PLANNING CONSULTATION RESPONSE

Application No	2025/1080
Proposal	Change of use of Working Men's Club (Use Class Sui Generis) to 9x supported living dwellinghouses for adults with staff facilities (Use Class C2) including associated alterations to the exterior of the building.
Address	2 Broad Street, Hoyland, Barnsley, S74 9DY
Date of Consultation Reply	04/02/26
Consultee	Highways Development Control

Proposed Basement Floor

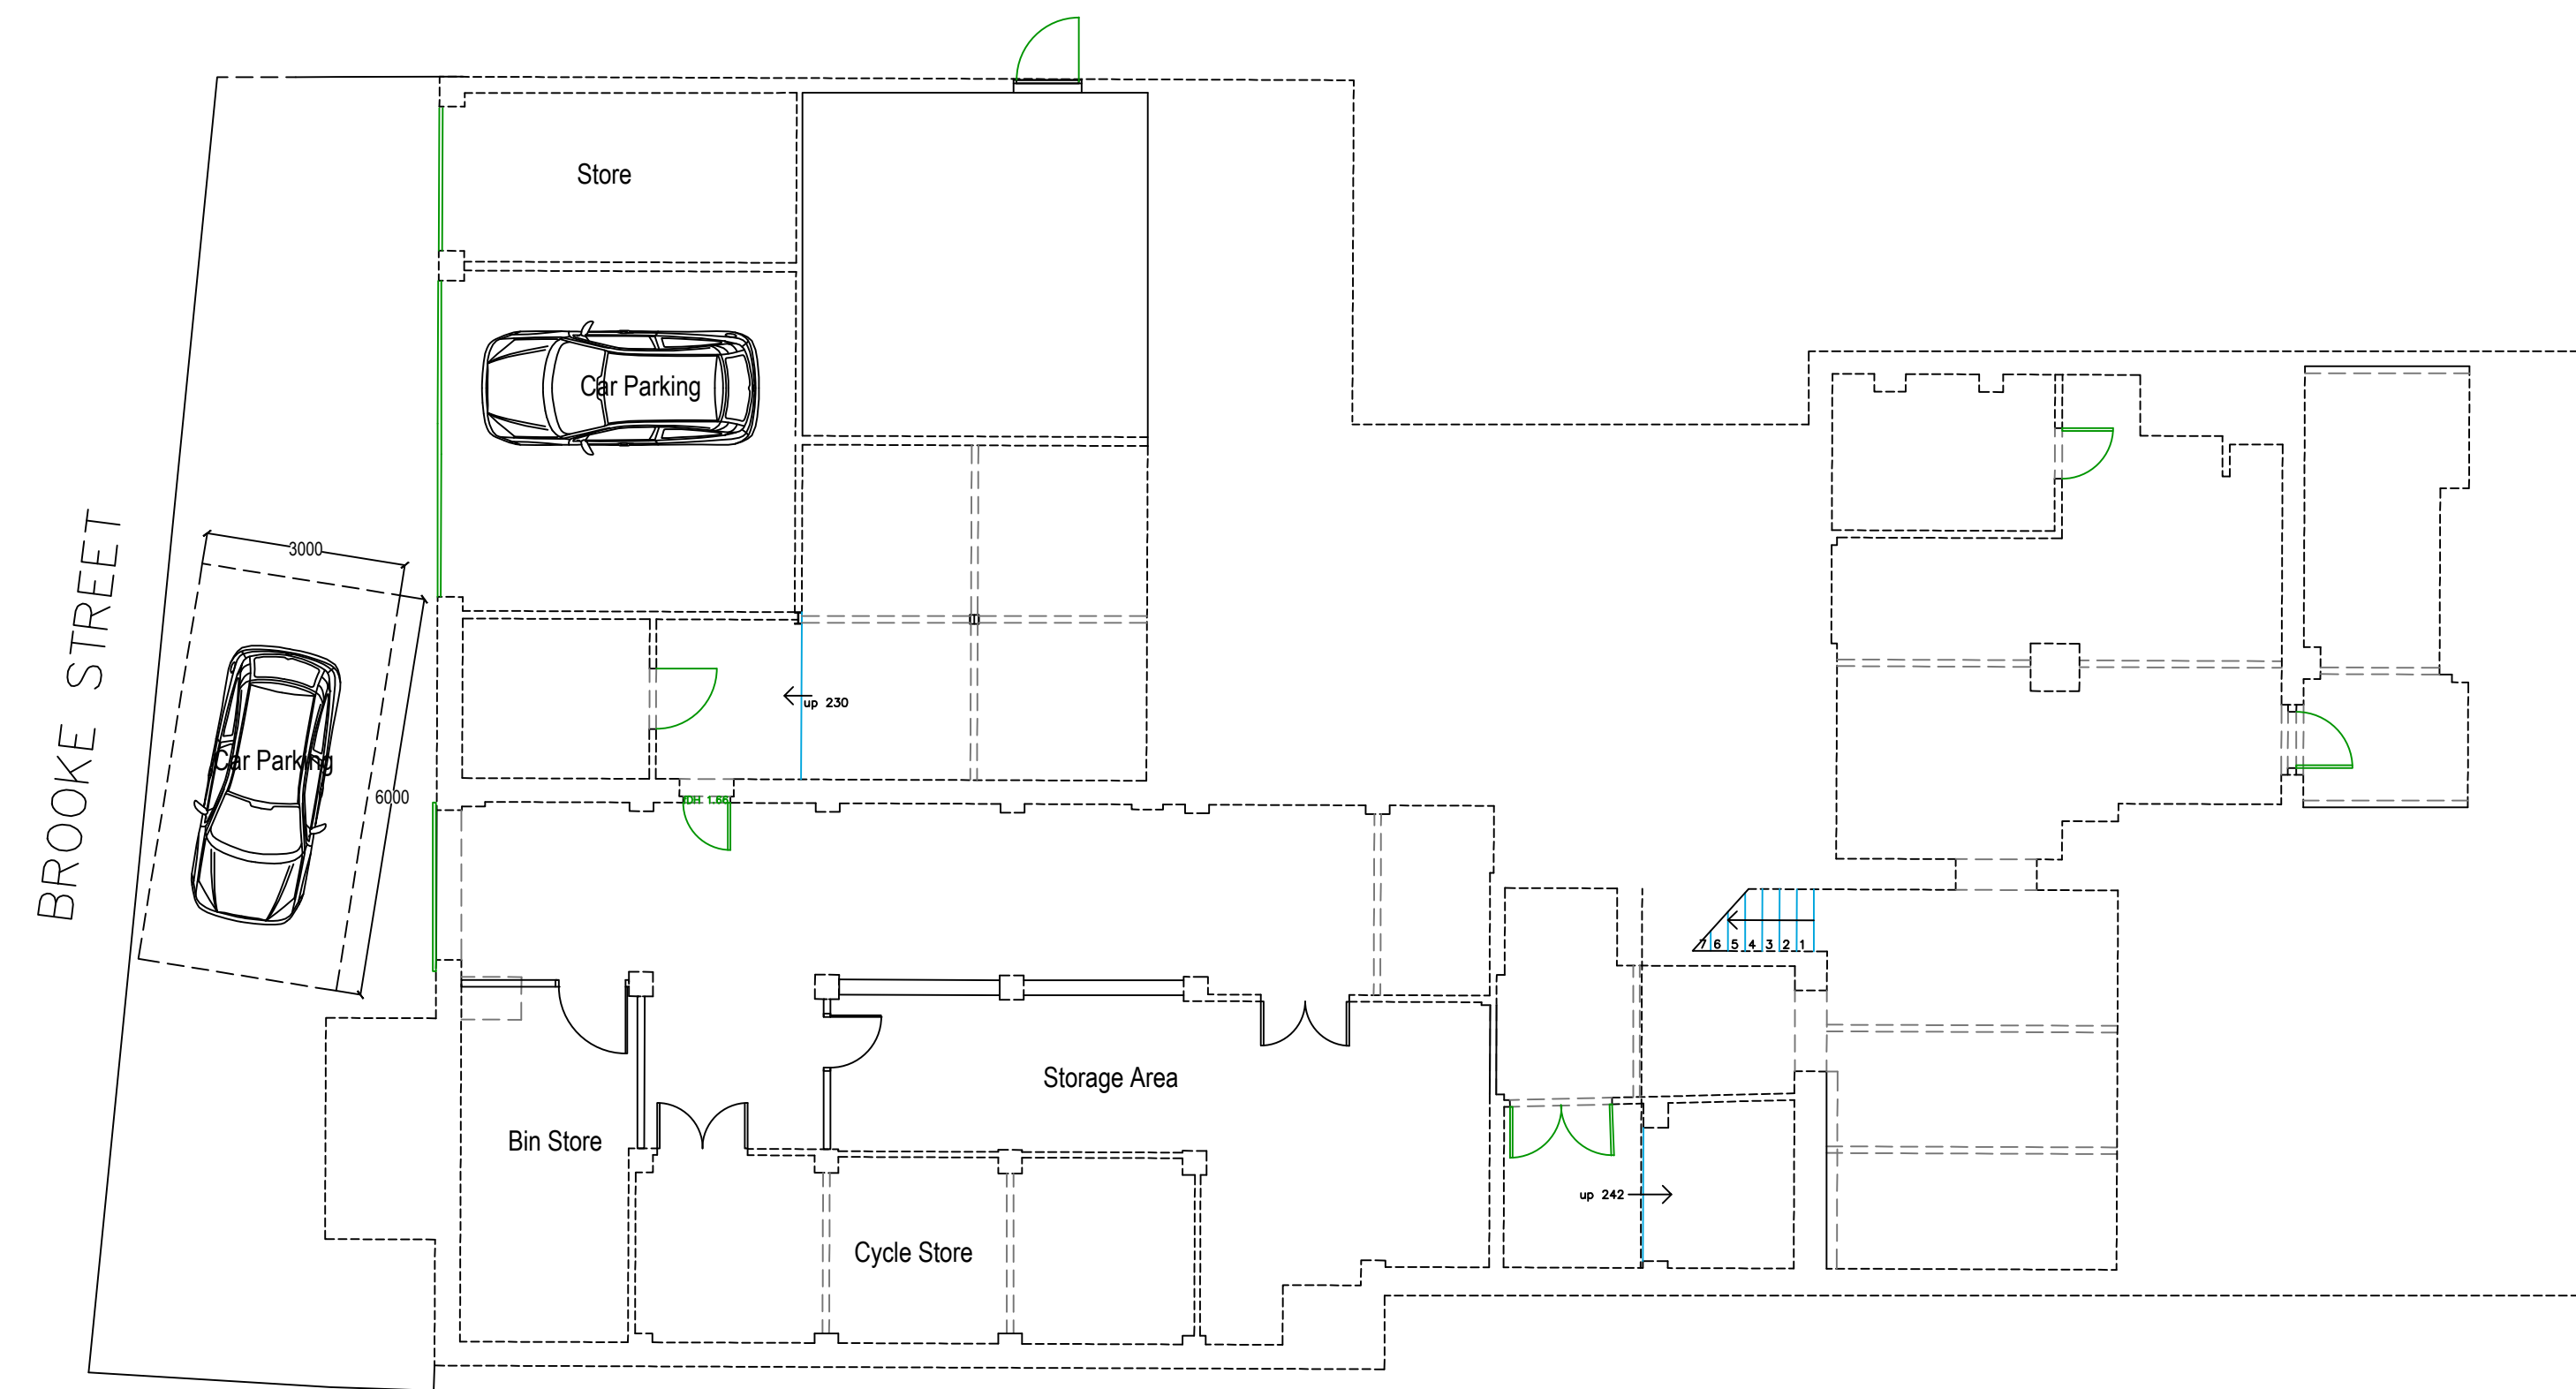
The existing building spans basement, ground and first floor levels. Historically, the basement formed garage space accessed from Brooke Street at the rear of the property. The current proposal seeks to retain a garage arrangement in the basement as formalised off-street parking, together with internal bin and cycle storage with refuse collection undertaken from Brooke Street.

In parking terms, the operational practicality of the basement layout is a critical issue. The single garages measure approximately 2.5 metres by 5.3 metres and the elongated space identified for tandem operation is approximately 2.4 metres by 15 metres. While such dimensions may theoretically allow multiple vehicles parking, the narrow width and enclosed nature are very likely to discourage staff from using the spaces as intended, and it is highly improbable that visitors would attempt to park within the garage area. In practical day to day operation, the effective on-site parking capacity would therefore be lower than suggested, with a heightened risk of displacement onto surrounding streets. These concerns are compounded by the fact that a multi vehicle tandem arrangement will routinely block in vehicles and is unsuited to staff shift changes or ad-hoc visiting professionals.

On this basis, while the site is sustainably located and capable in principle of supporting the proposed use, the current basement layout and the lack of detailed information as to the operation requirements of the proposed use, do not yet demonstrate acceptable parking provision.
